Consultation Response from KC, Landscape - Emma Mills

2025/90889 Former Combs Hostel, Hall Lane, Thornhill, Dewsbury, WF12 0PL

Demolition of existing hostel and erection of residential development comprising 34 dwellings

Date Responded: 14.04.2026

Preliminary Drainage Plan

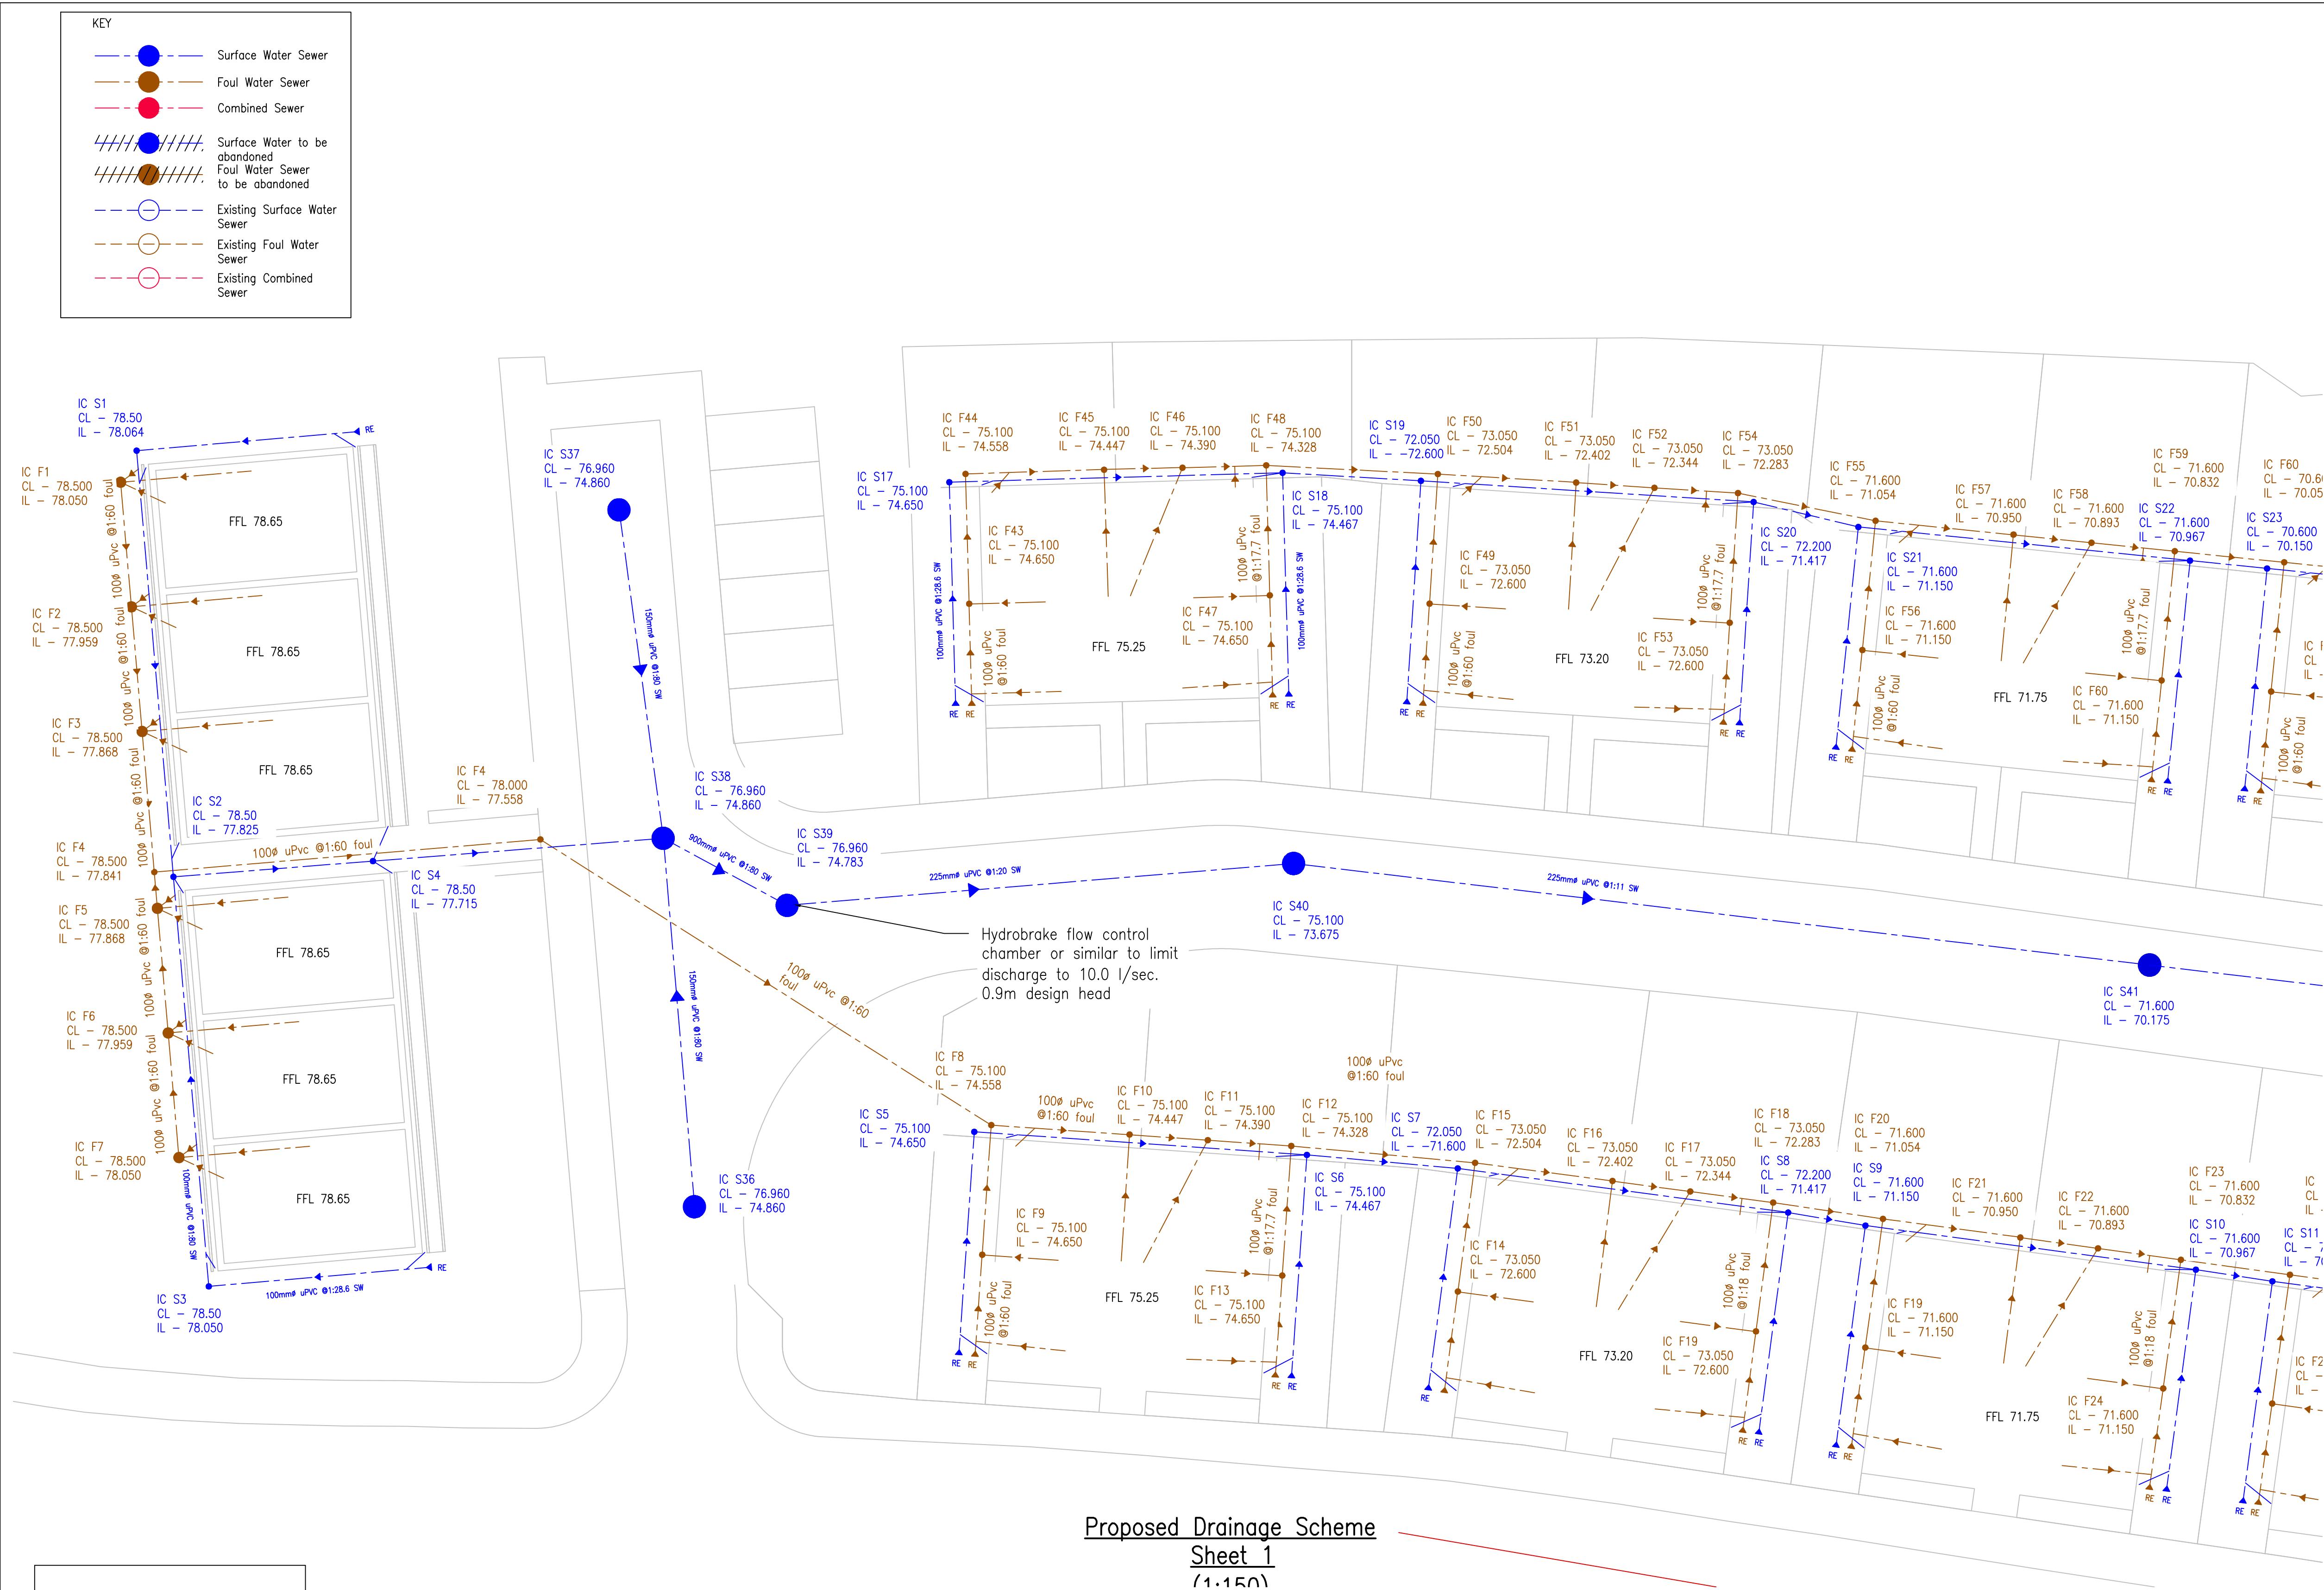
Please show drainage infrastructure on the landscaping plans, to demonstrate no conflict between trees and drainage.
